October 8<sup>th</sup>, 2013

**RE: ZONING BY-LAW AMENDMENT  
2940 & 2946 BASELINE ROAD (FILE #D02-02-12-0077)  
PLANNING RATIONALE ADDENDUM AND RESPONSE TO TECHNICAL COMMENTS**

Front Elevation  
Scale 1:250

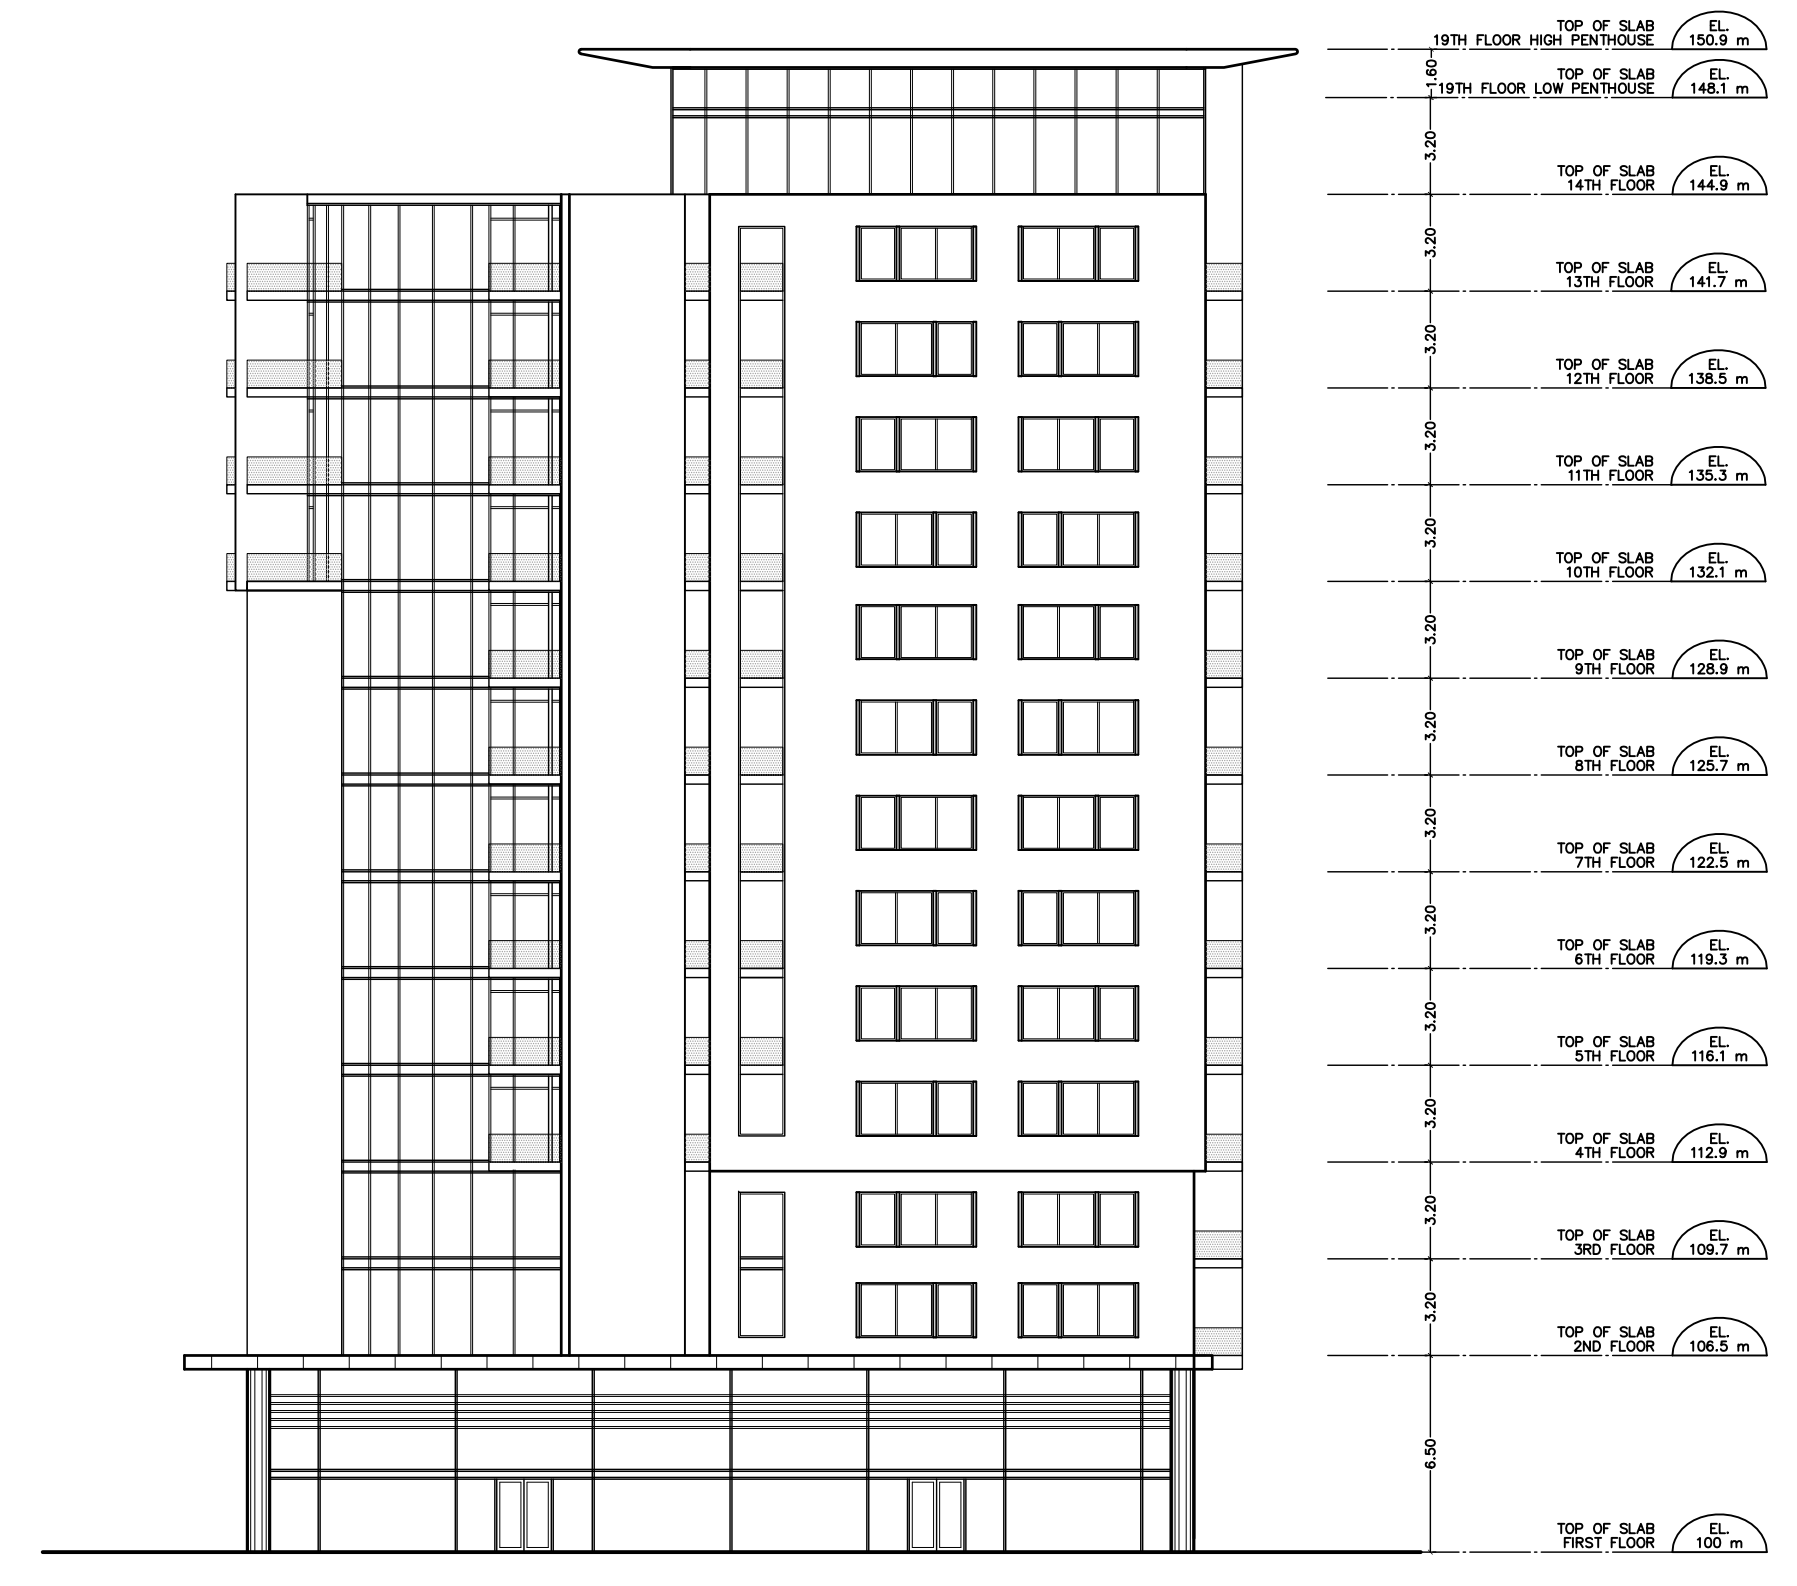
- The effect on the skyline of the design of the top of the building is not addressed.

- Architectural design (e.g. the use of angular planes, cornice lines) – There is a lack of information regarding the design of the bases or podiums.

- The top of the building is designed with a sloped roof to add visual interest, the eastern halves of which are grated to ensure views and allow sunlight to pass through. Generous glazing at the upper levels of the buildings will reduce visual impacts, and trees on the amenity spaces will also be visible from a distance. The roofs will be visible from all directions.

- NEUF, the project architect, will provide colour renderings and elevations, to better understand the proposed architecture. In the interim, please refer to Perspectives drawings in the submission package.

JUNE 21 9:00

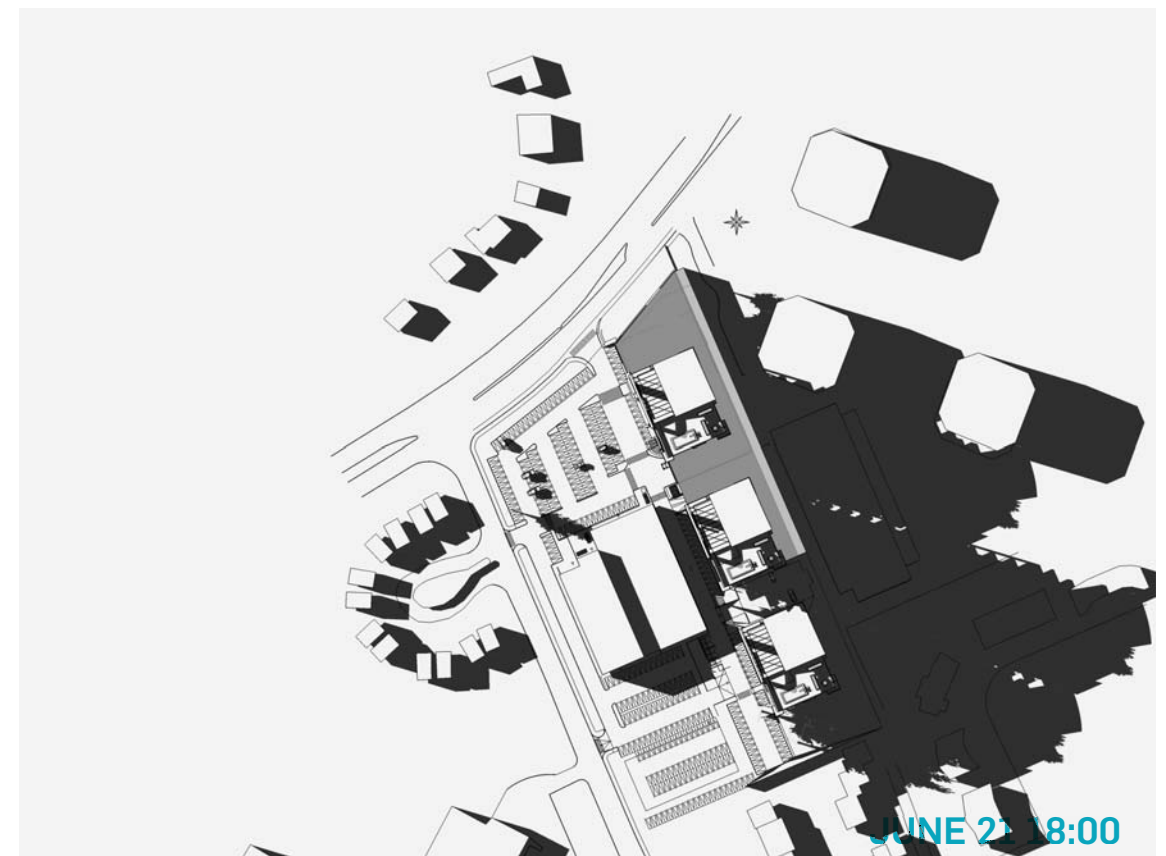
- Sunlight – The Shadow Study appears to have the most impact on the adjacent employment lands to the east of the site. The shadows are not clearly shown for June 21. Shadows are not visible at all at 16:00 on December 21.

- NEUF has prepared an updated shadow study, in support of the revised application.
